ATLASSIAN CENTRAL DEVELOPMENT

SSD-10405 AMENDMENTS TO APPROVED SSDA DESIGN REPORT - SSDA MODIFICATION 11

30/09/25

Figure 1 Proposed Crown Event Space Amendments on Level 35 and 36

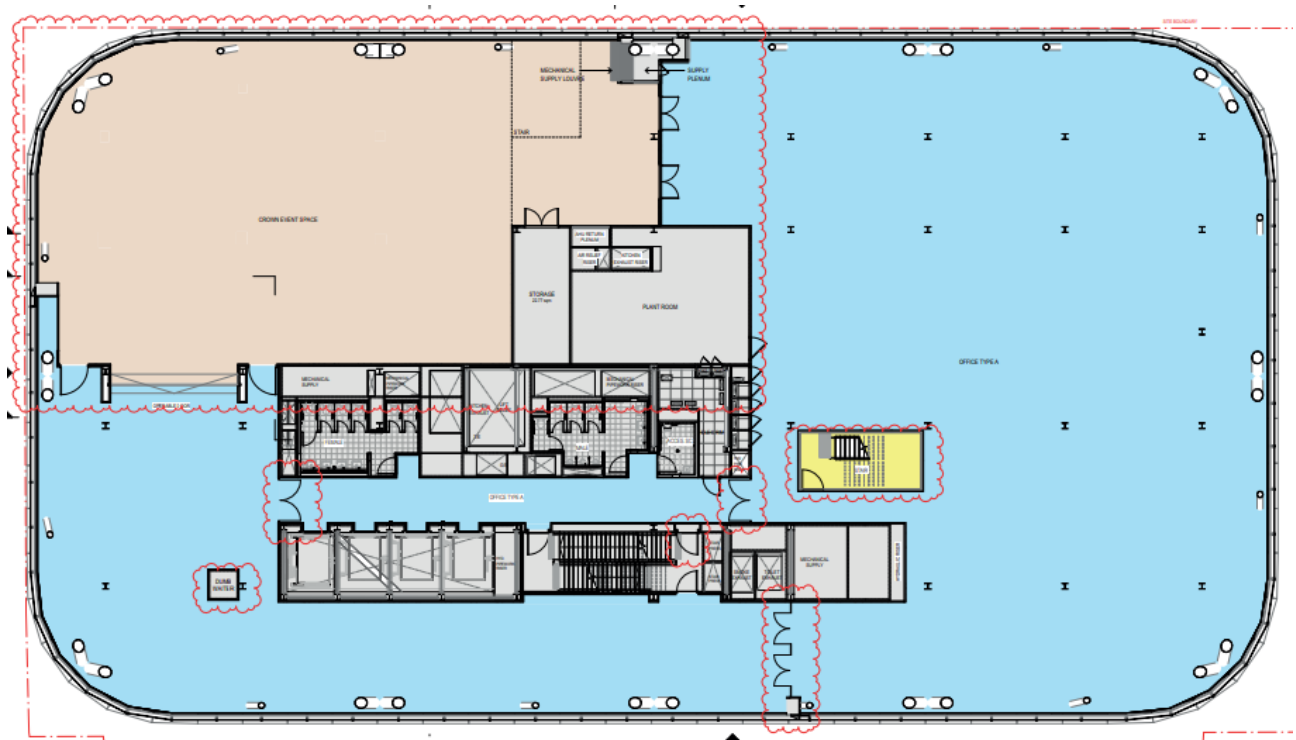
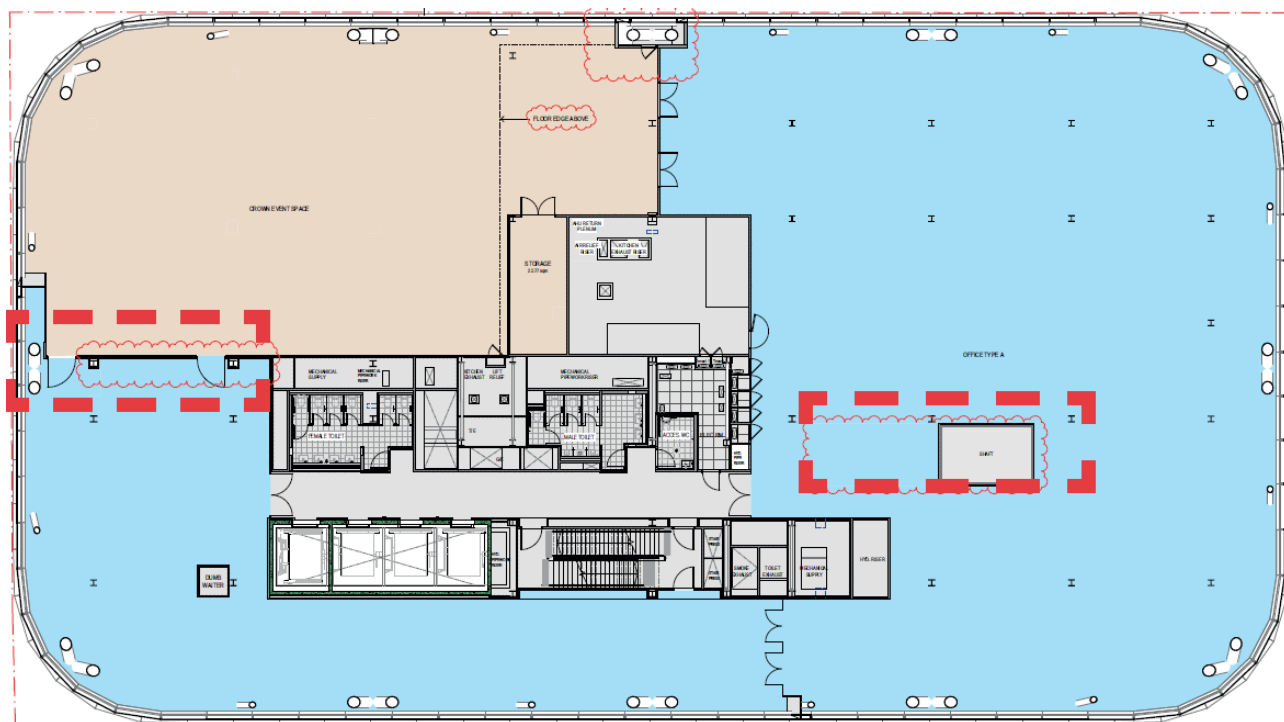
- 1. Remove stair void for event space stair between Level 35-36
- 2. Remove crown stair and Shift the crown stair voids one structural bay to the south
- 3. Remove the Skyfold door, replace with full-height wall

Approved Level 36 Plan

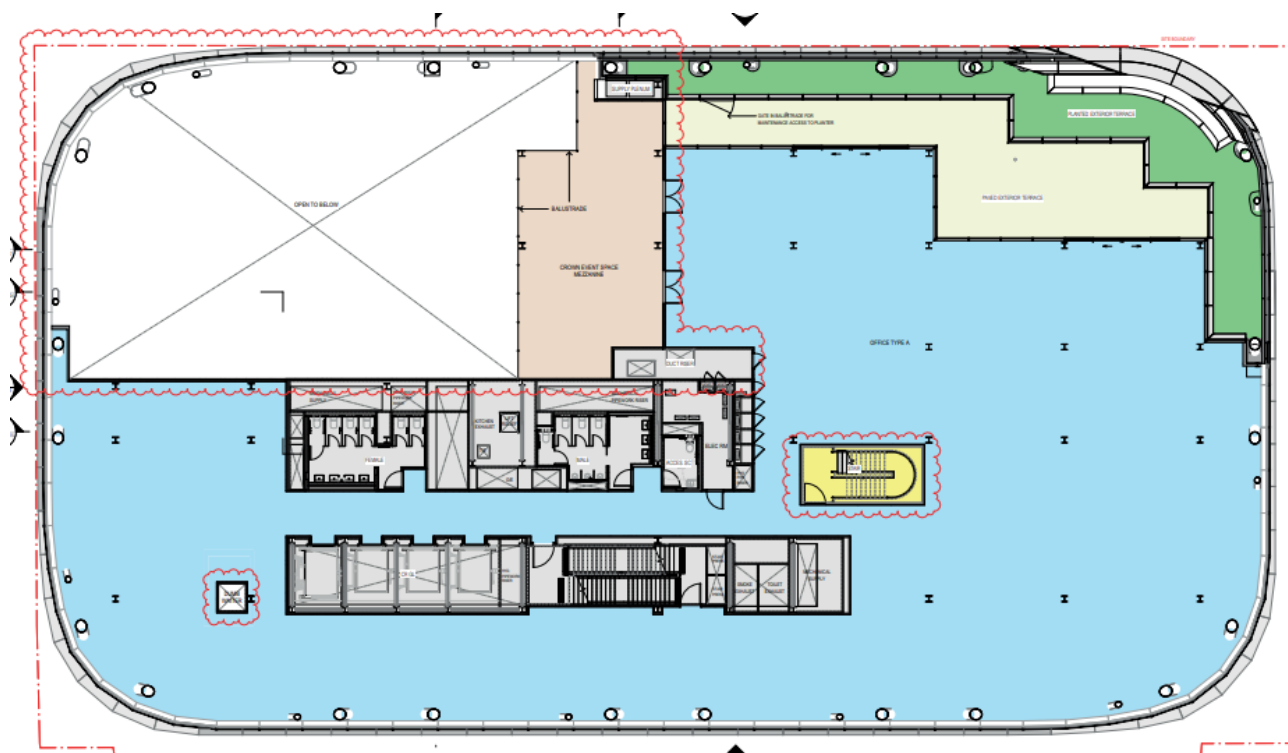
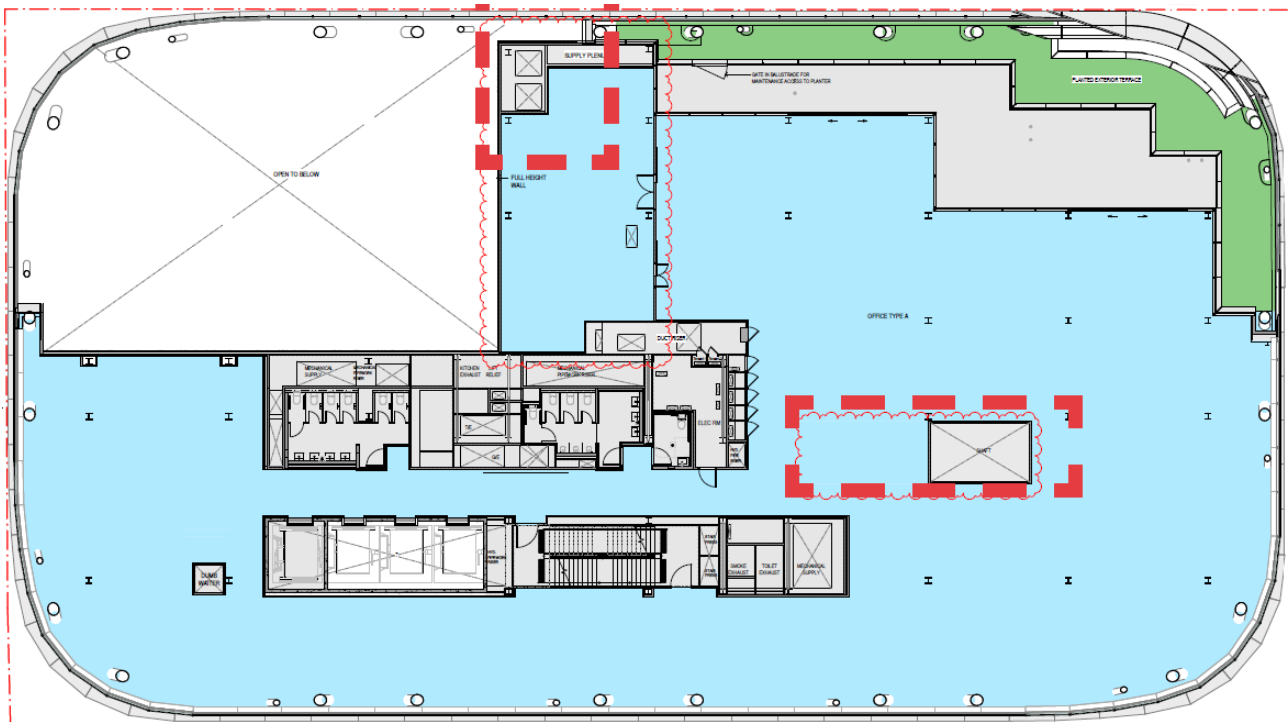
1. Remove stair void for event space stair between Level 35-36. Replaced with supply air plenum
2. Remove crown stair and Shift the crown stair voids one structural bay to the south
3. Replace the mezzanine base build balustrades with full-height wall

Approved Level 37 Plan

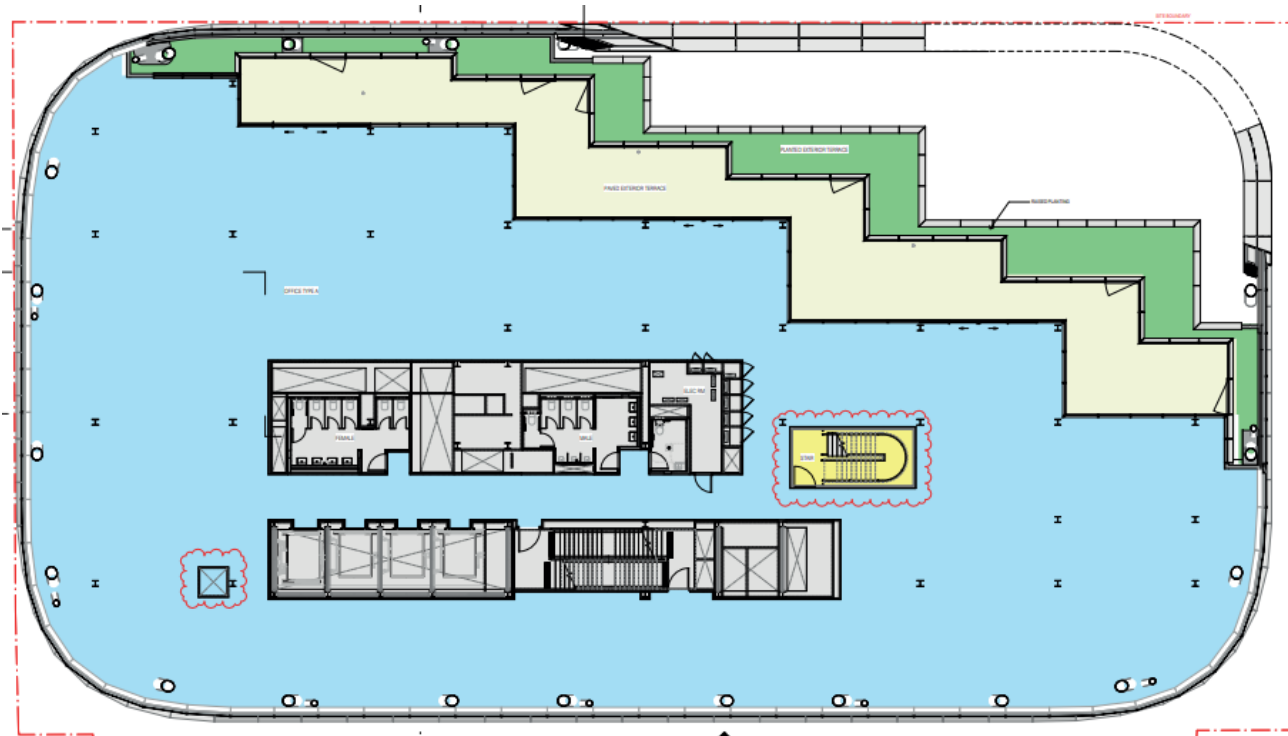
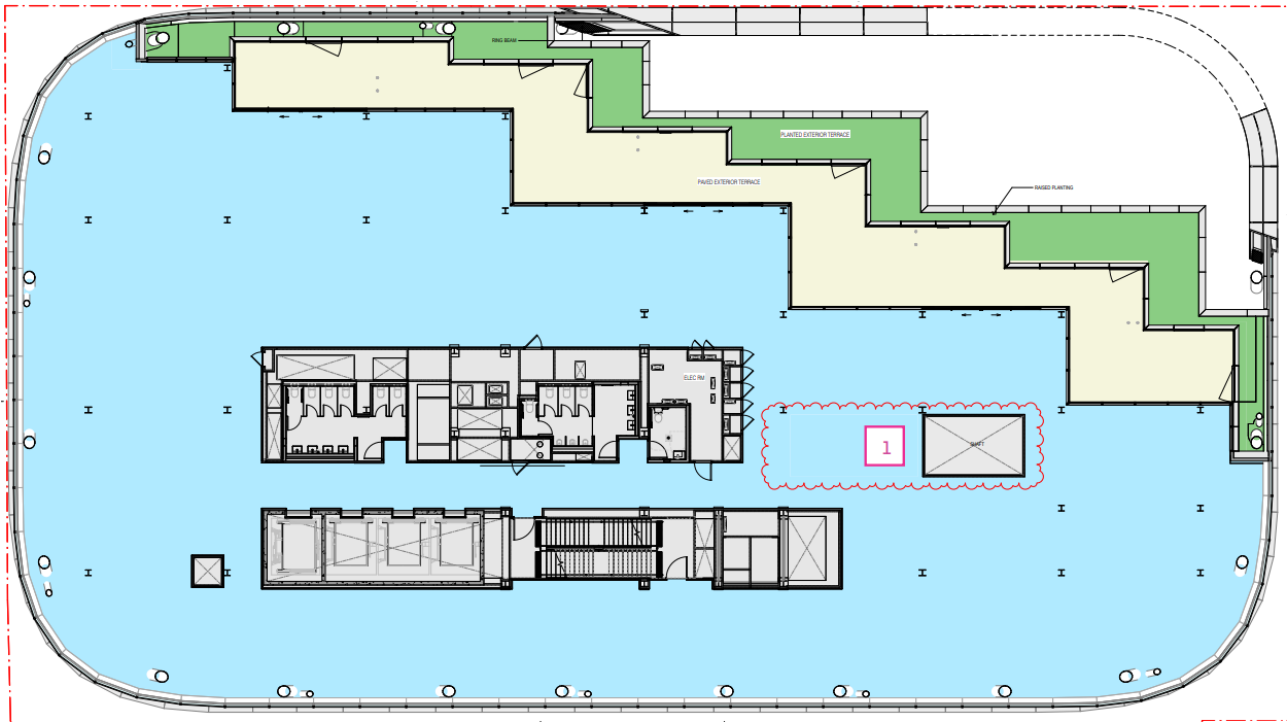
- 1. Remove crown stair and Shift the crown stair voids one structural bay to the south

Approved Level 38 Plan

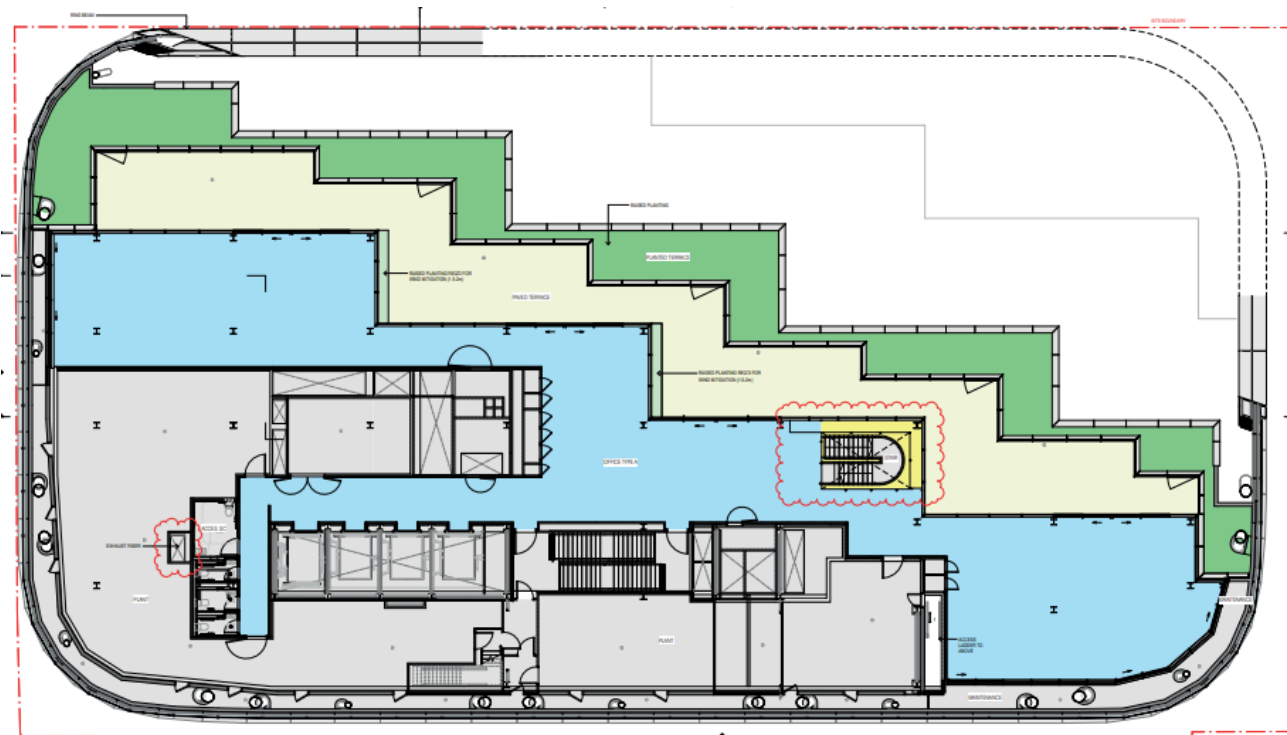
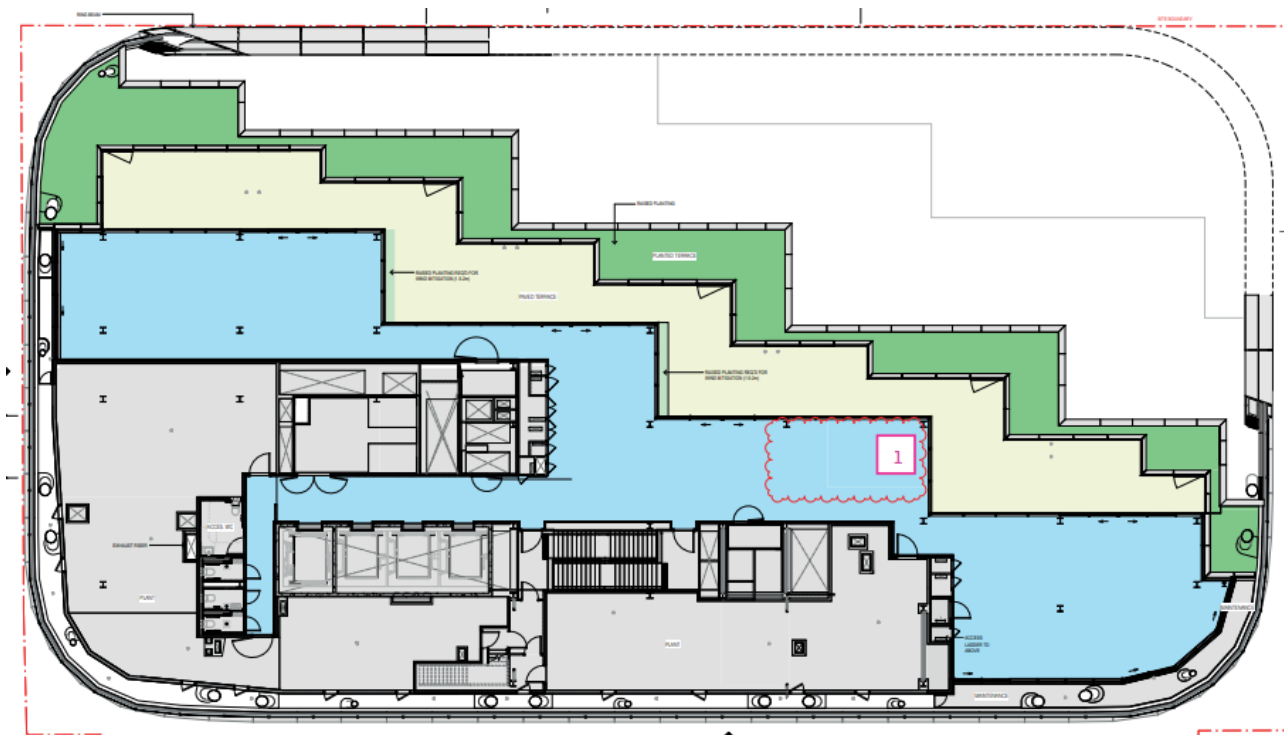
- 1. Remove stair and void.
